## **Response to submissions – Minto Resource Recovery Facility (SSD 7462)**

This letter responds to the items raised in the *Bingo Resource Recovery Facility, 13 Pembury Road, Minto (SSD 7462) Request for Response to Submissions*, issued on 22 August 2017 and 14 February 2018.

A submission comprising a letter (dated 22 August 2017) was received from DPE. Several comments were provided and responded to in Table 1. Additional comments were provided via email on 14 February 2018. These additional comments have been incorporated and responded to within Table 1 below.

**13 PEMBURY ROAD,
MINTO
LOT 1 DP 1013852**

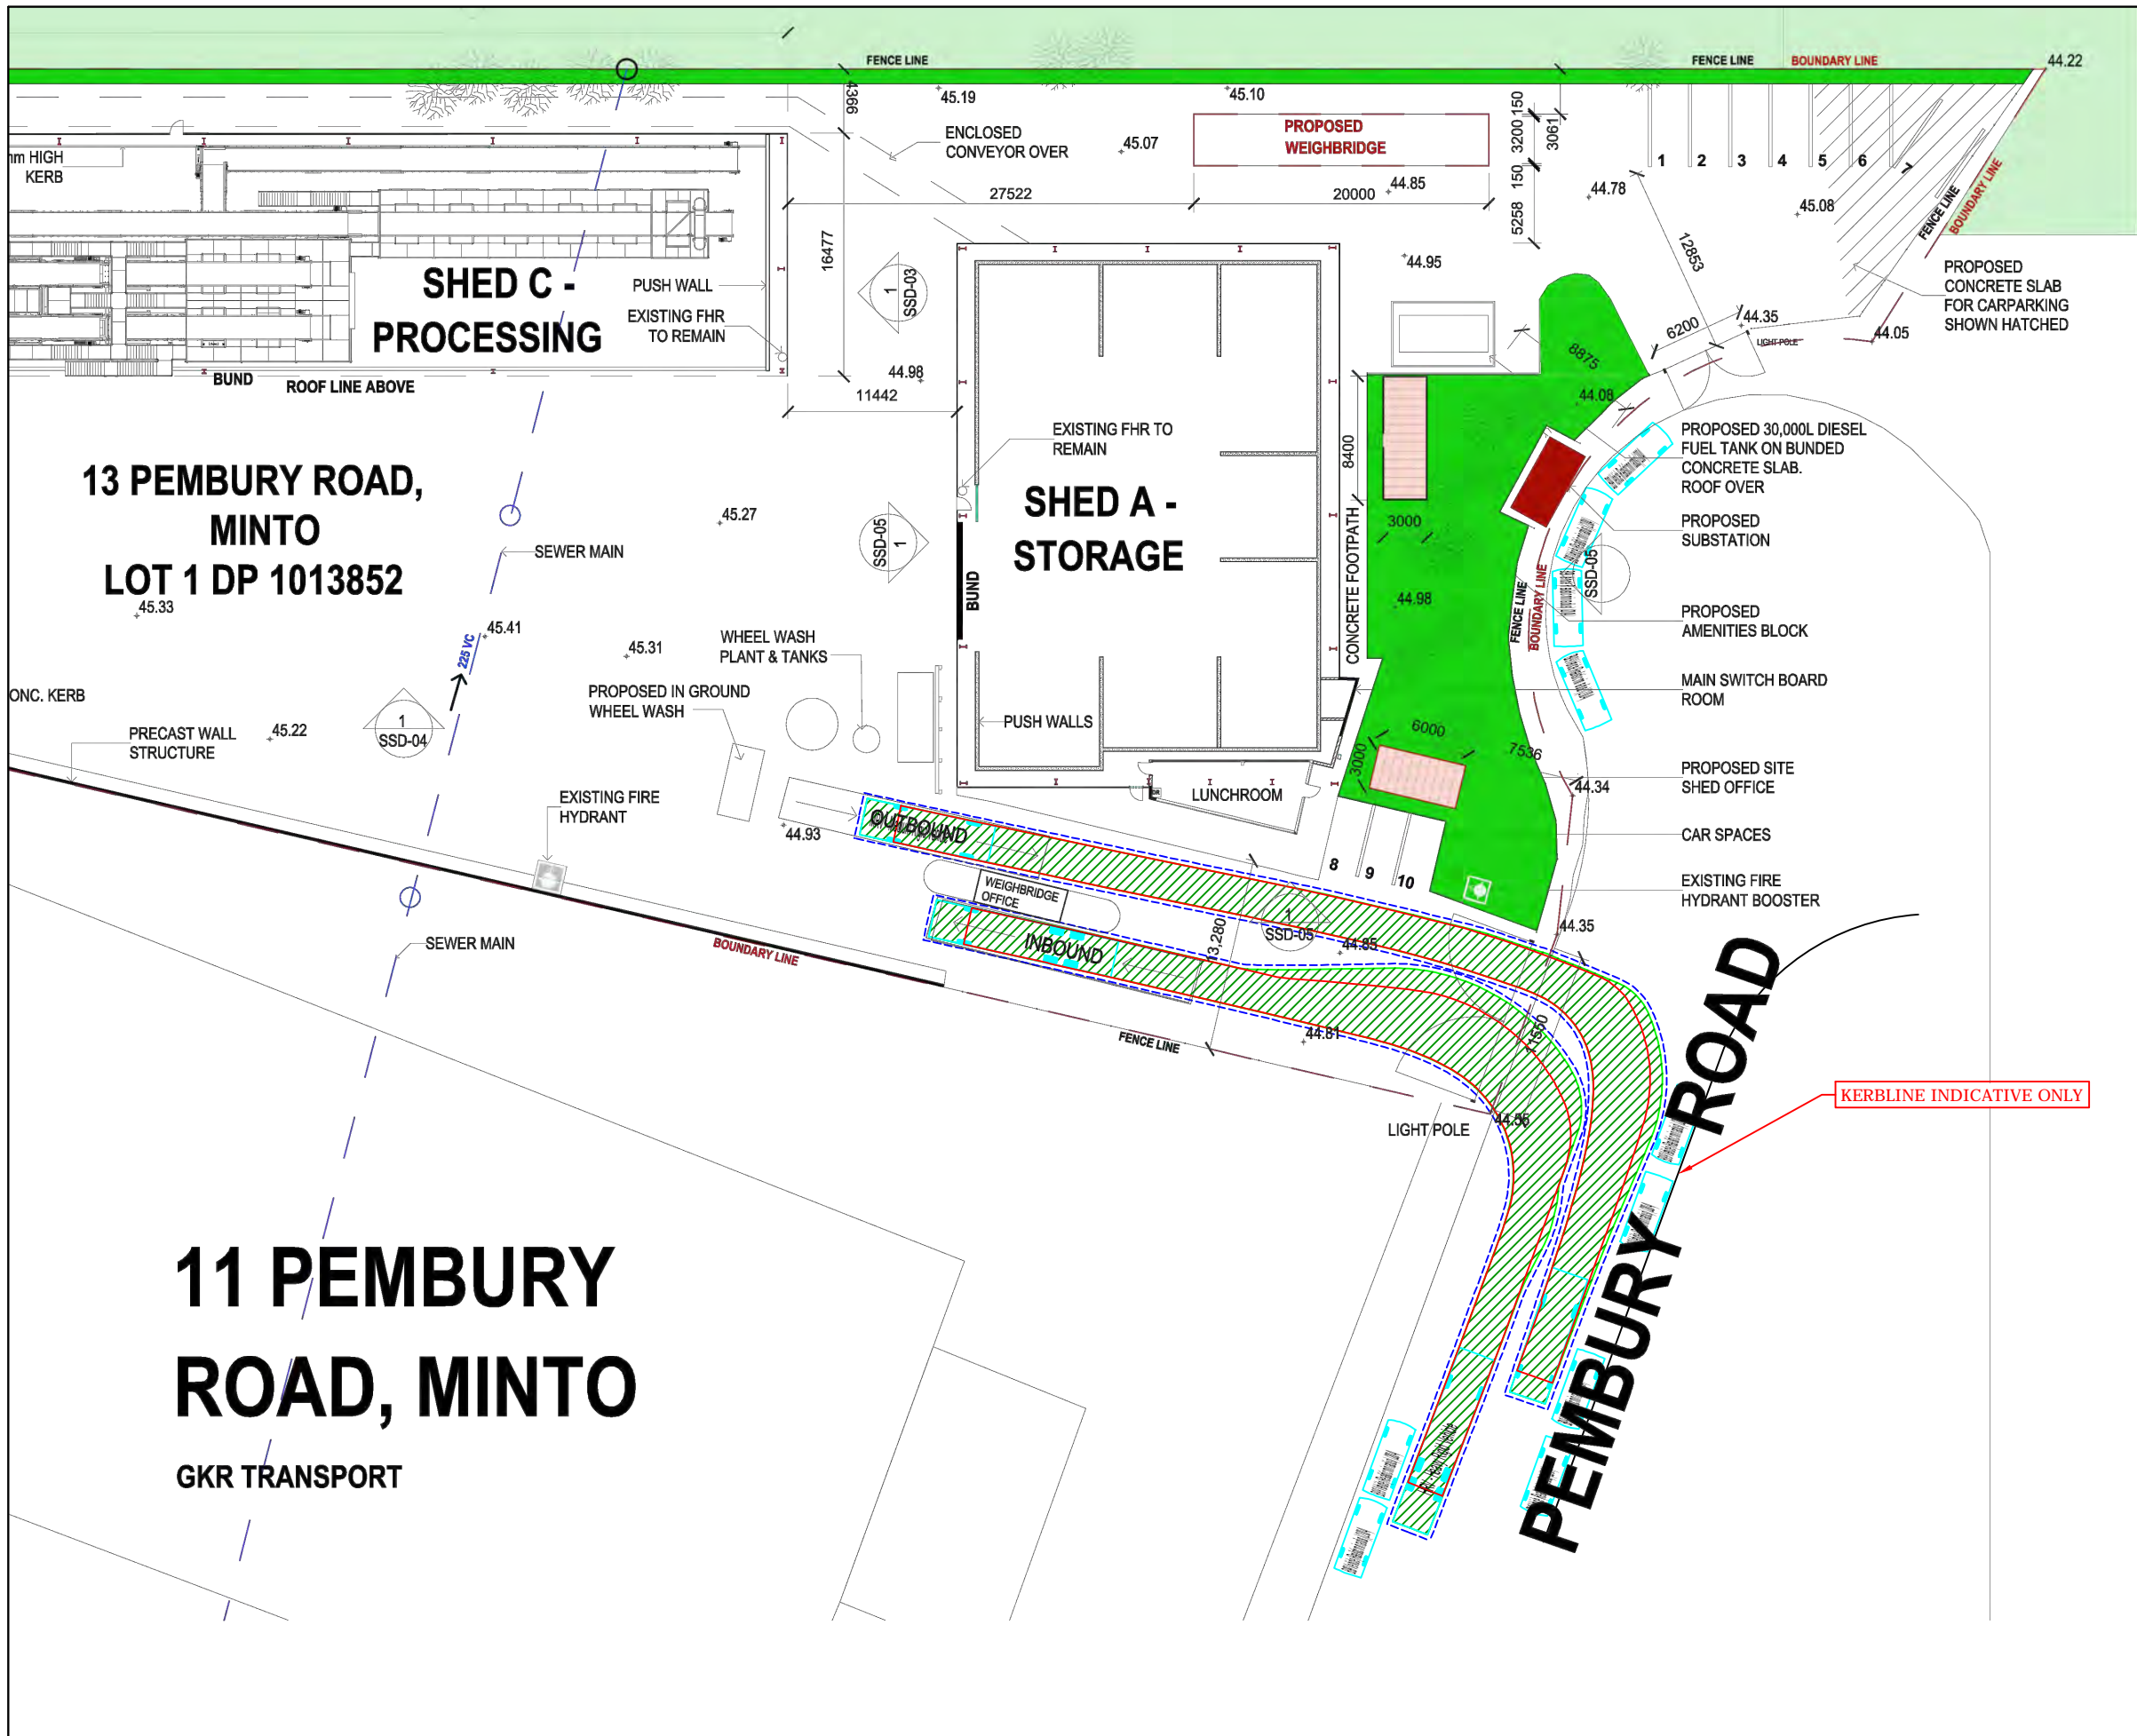
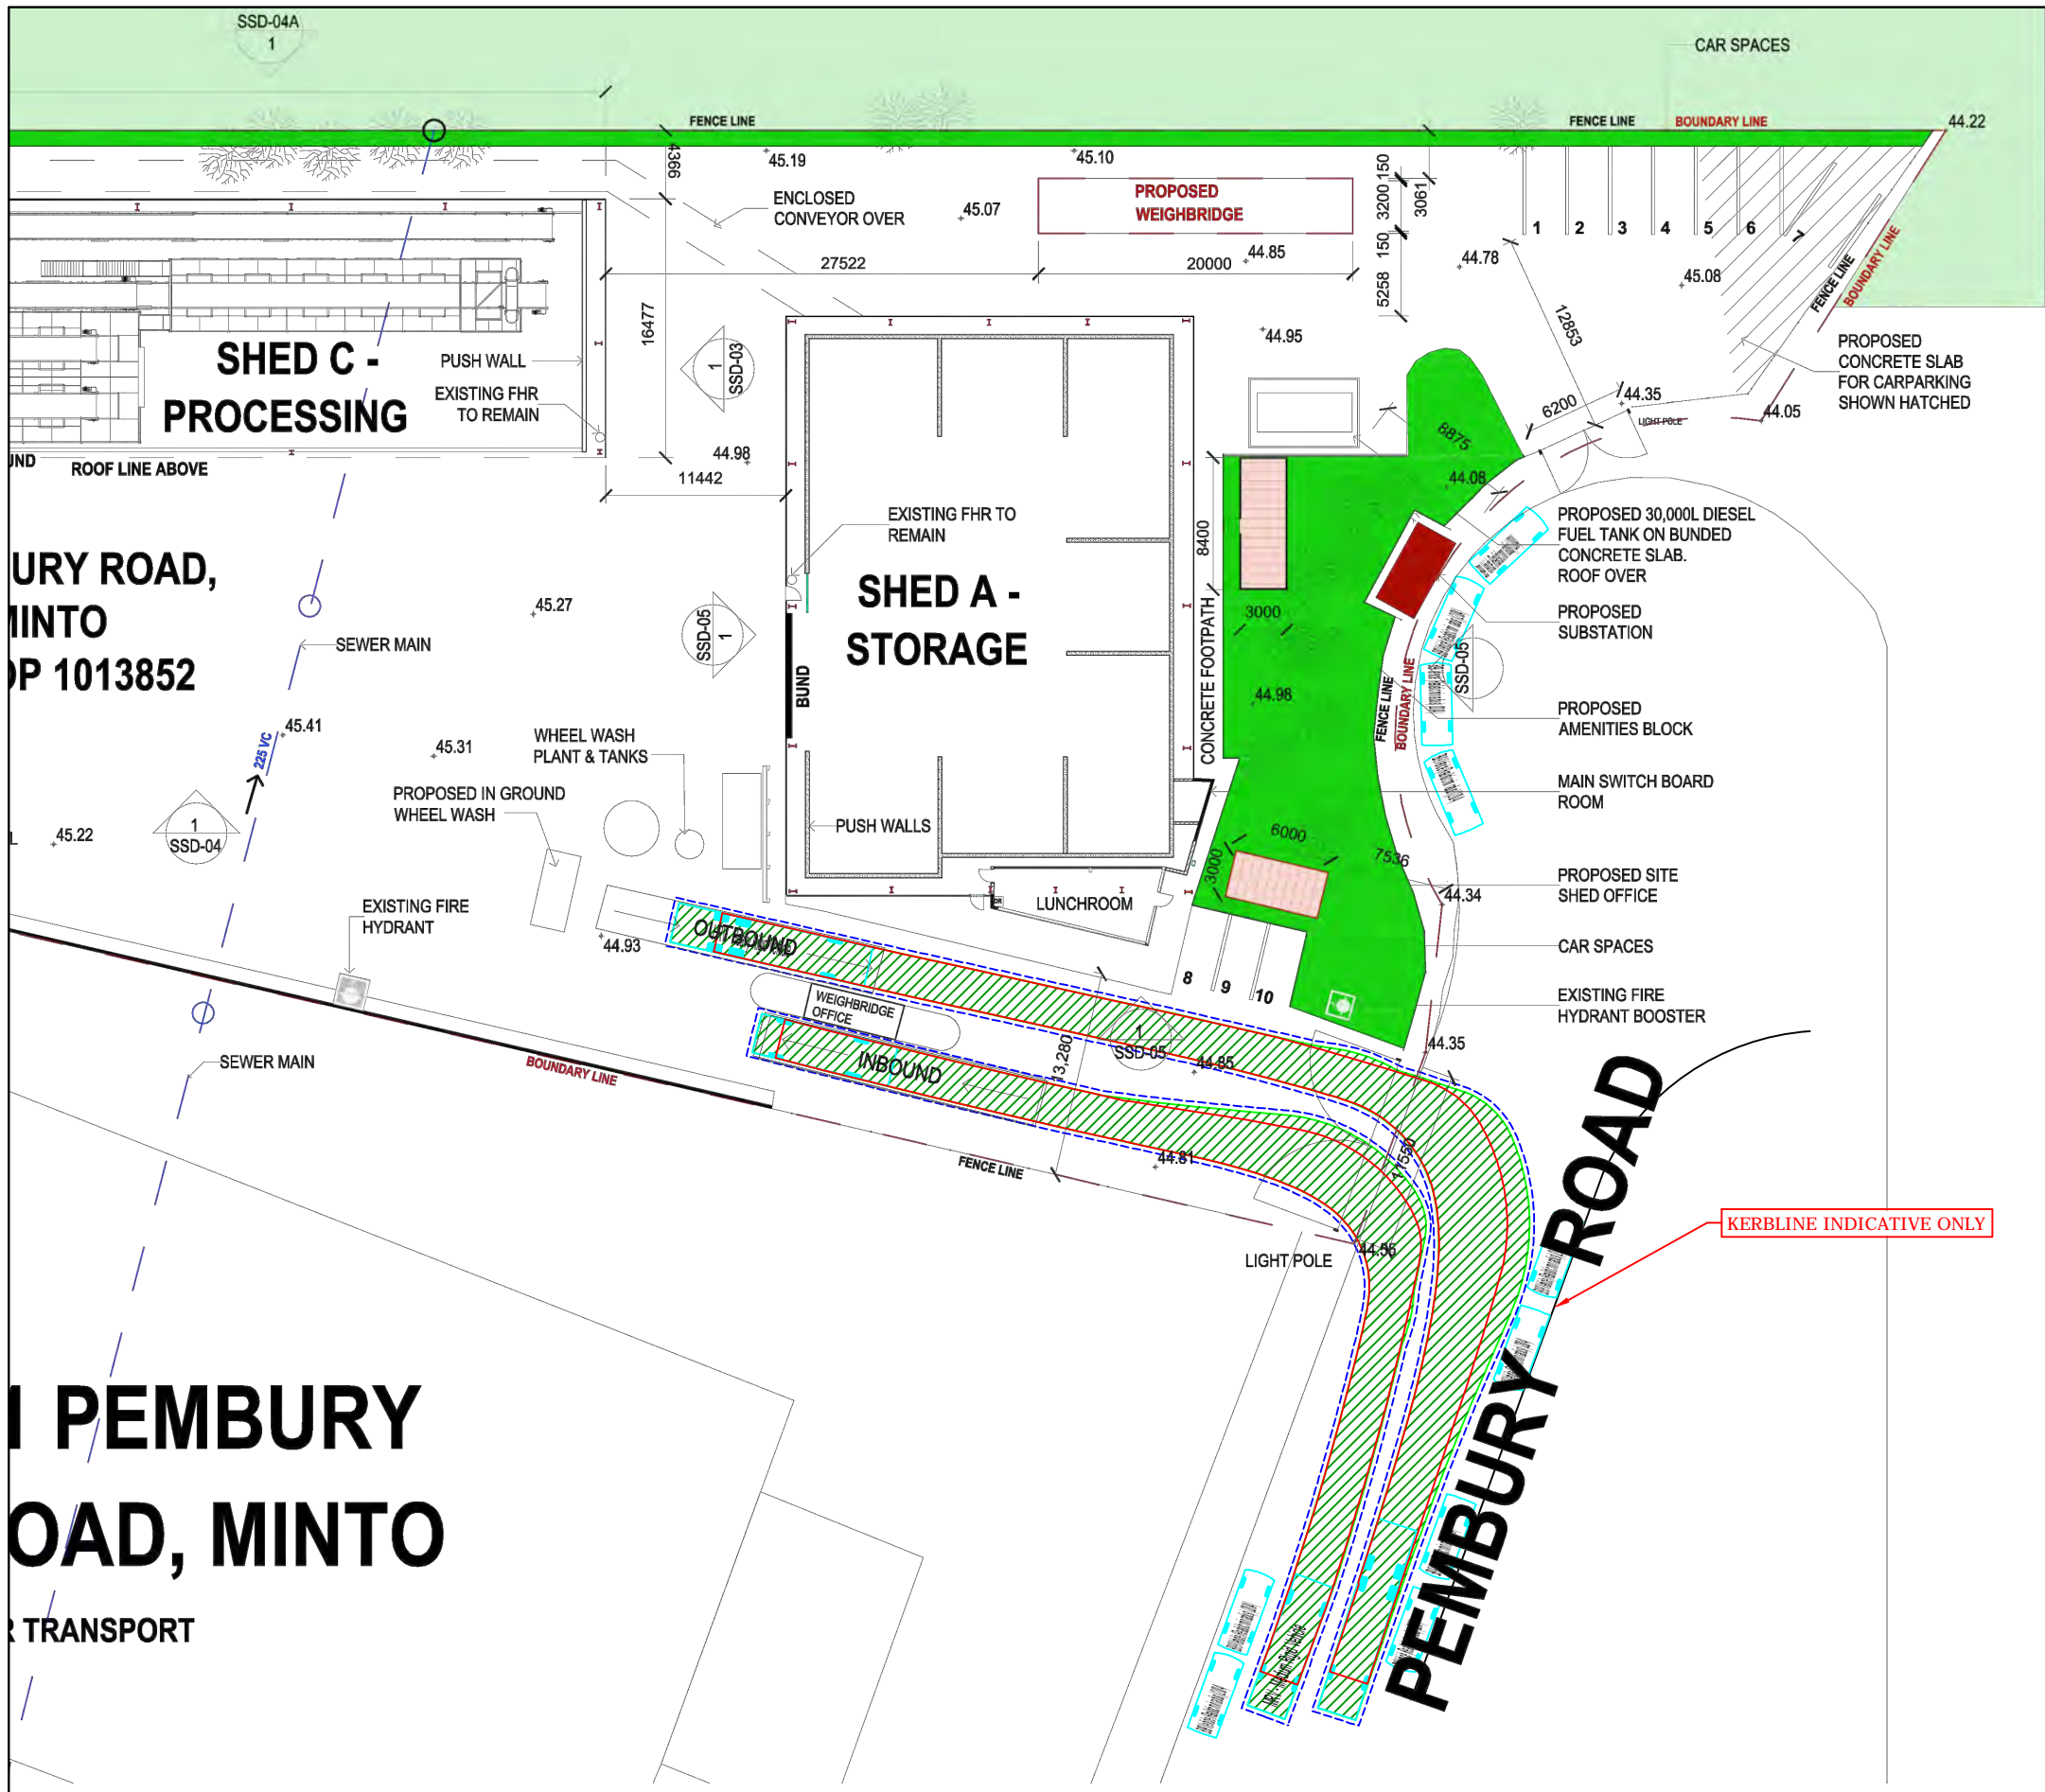
Provide plans showing the swept paths of the front-end loader proposed to be used to move waste on-site and vehicles used for waste collection. The plans should include the stacking of vehicles within the site to demonstrate there is sufficient space onsite at peak periods.	<p>As noted and described in Section 6 of this RtS a number of amendments have been made to the Proposal following the exhibition of the EIS in response to submissions received. These include amendments to further optimise the internal site layout and improve safety (demonstrated by amended swept path analysis) for vehicle movements within the Proposal site, including removal of minor internal walls and cladding. It is proposed to remove the northern wall of Shed C to ensure optimal swept paths can be achieved by heavy vehicles safely and efficiently.</p> <p>Movement of the excavator between Shed A and Shed C has been considered while assessing the site layout. The key movements for the excavator are as follows:</p> <ul style="list-style-type: none"> <li>When there would be a waste collection truck loading-up adjacent to Shed A, the excavator would complete short movements between the waste storage bays within Shed A and a truck parked alongside Shed A.</li> </ul>	Section 6 of the RtS Addendum TIA (Appendix I of this RtS)
